Date: 07-Sep-2026
Our Ref: 2026/92212

**Application for a non-material amendment following a grant of planning permission,
Town and Country Planning Act 1990**

**Non material amendment to previous permission 2022/93868 for erection of single
storey rear extension, rear dormer, formation of raised deck area, external
alterations and dropped crossing
477, New Hey Road, Salendine Nook, Huddersfield, HD3 3XG
Application Number: 2026/92212**

Drawing no.
104
Revisions

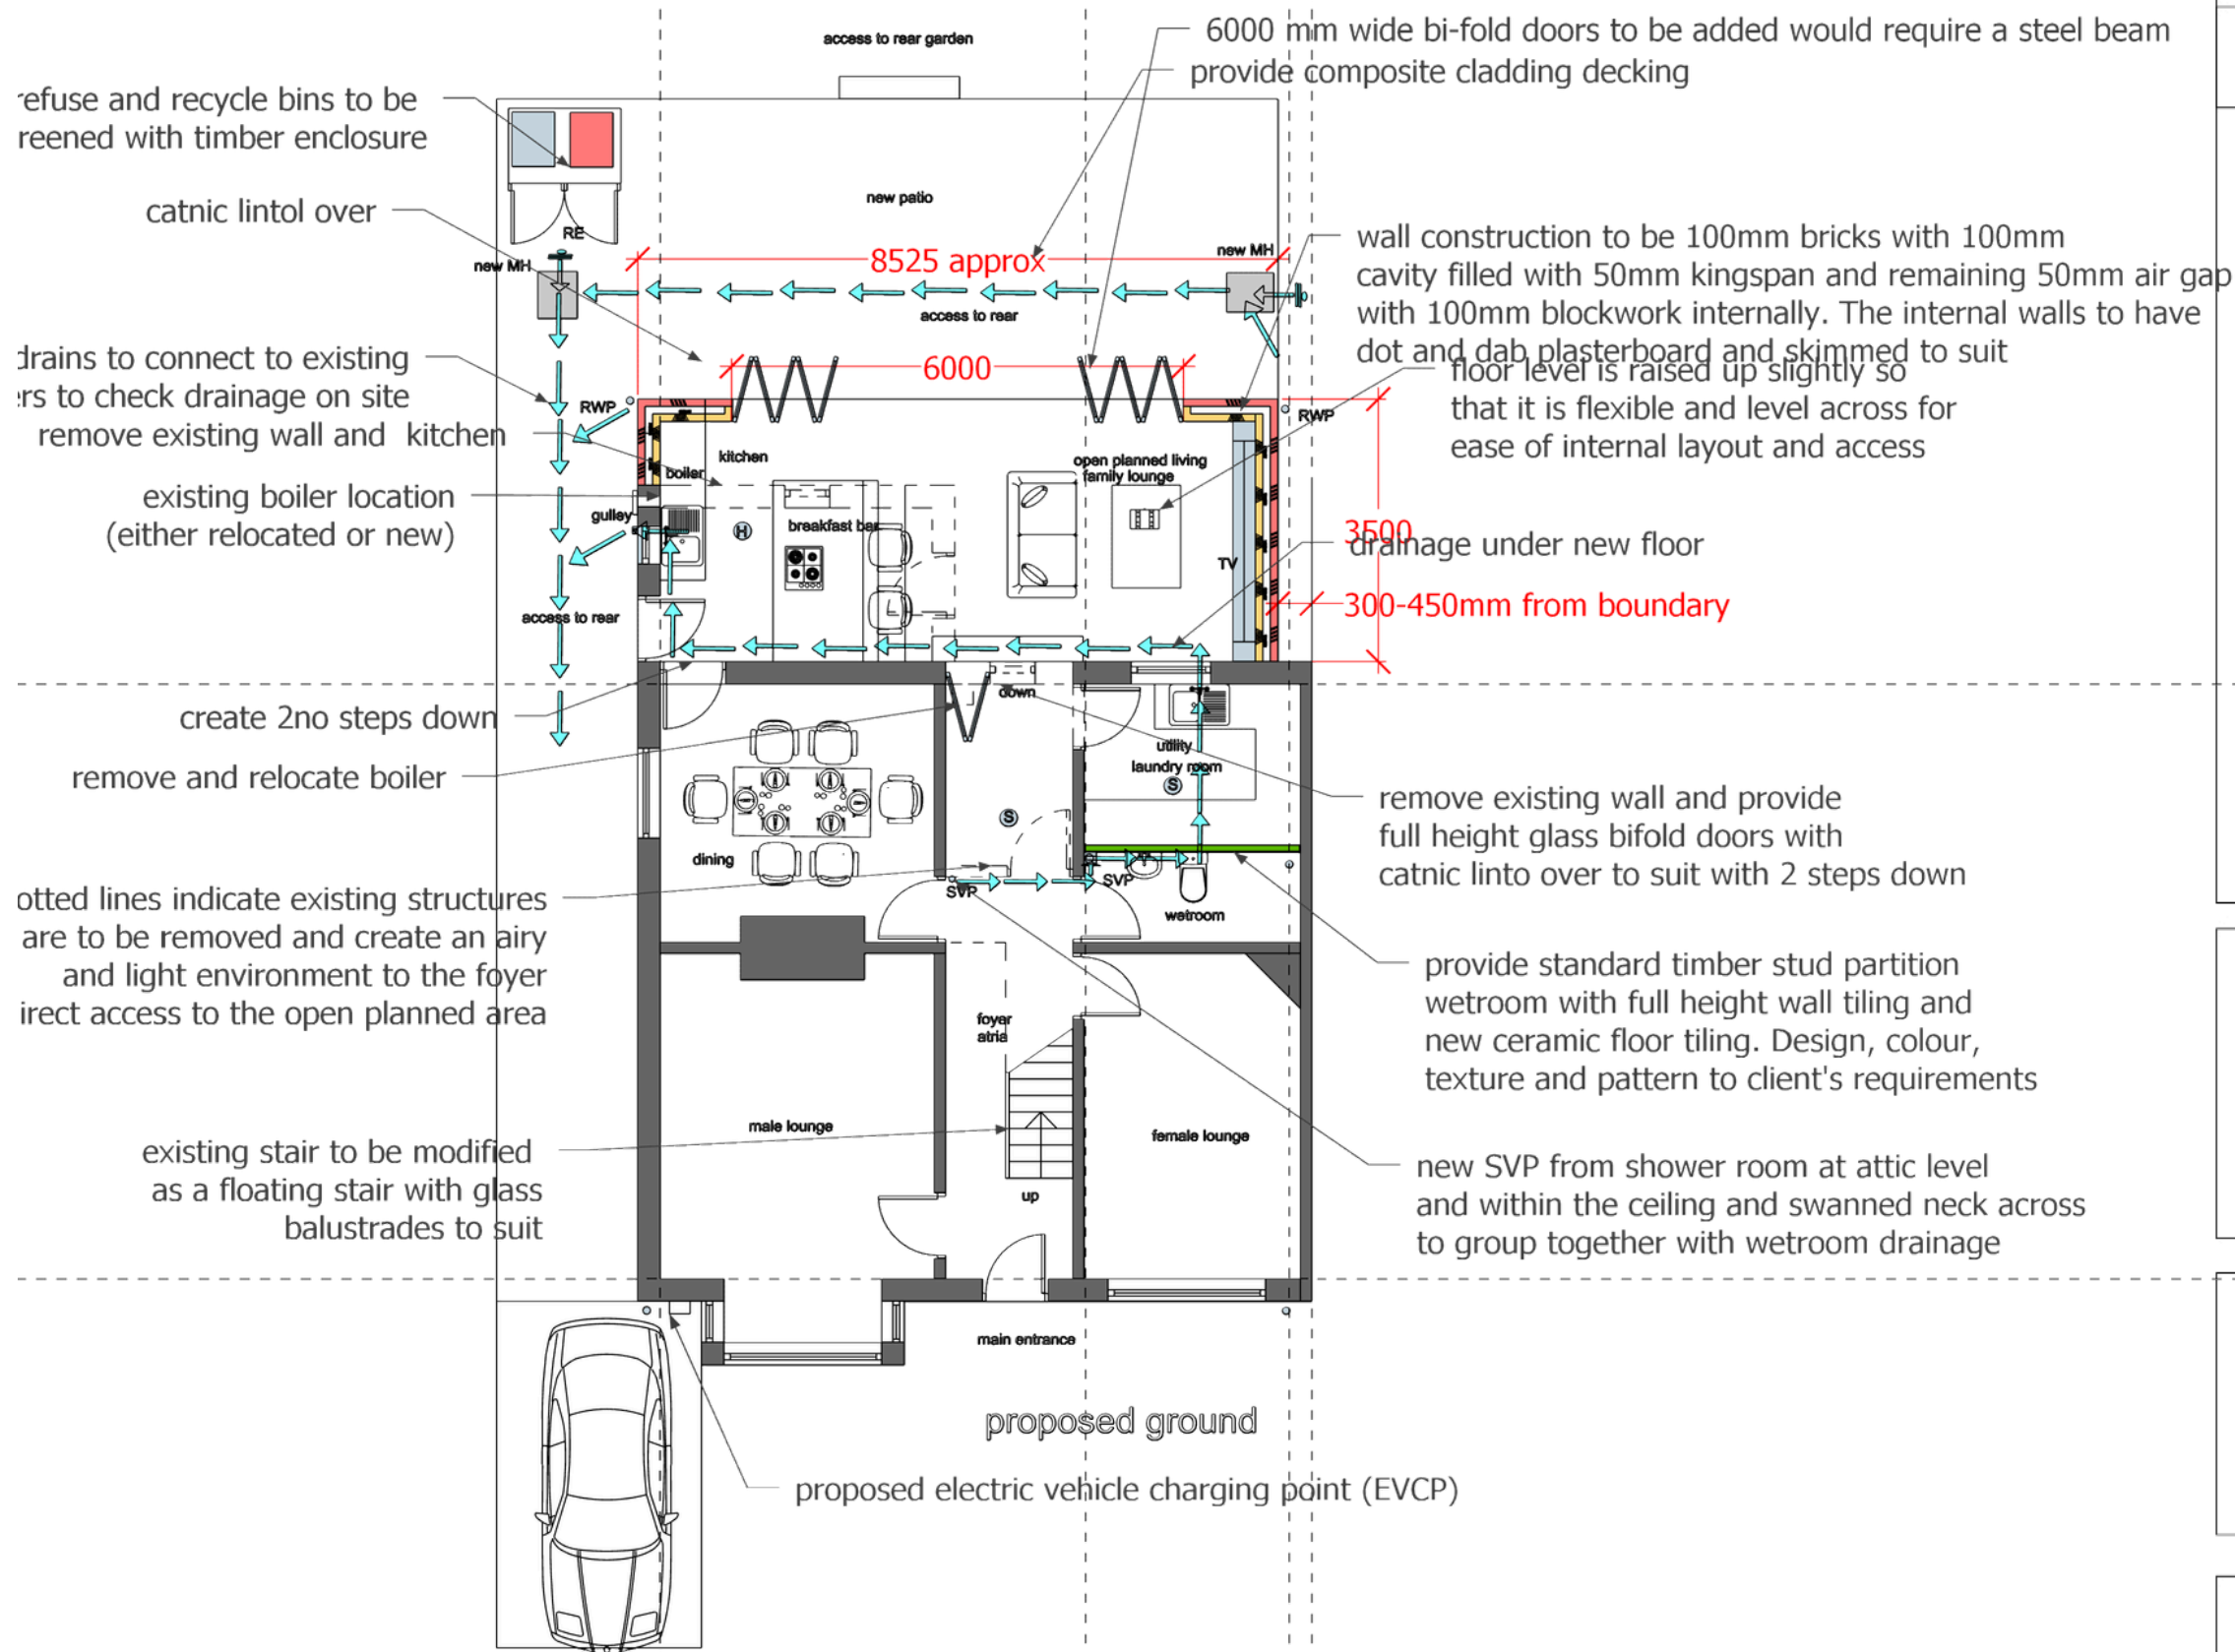
The amendments sought for converting the existing pitched roof on the rear extension to a
flat roof and installing a roof light and replacing the two bi-fold doors in the rear elevation
with a single 6-meter bi-fold door as shown on drawings number 106, 105 and 104 are
considered acceptable as a non material amendment to the approved scheme under
planning reference number 2022/93868.
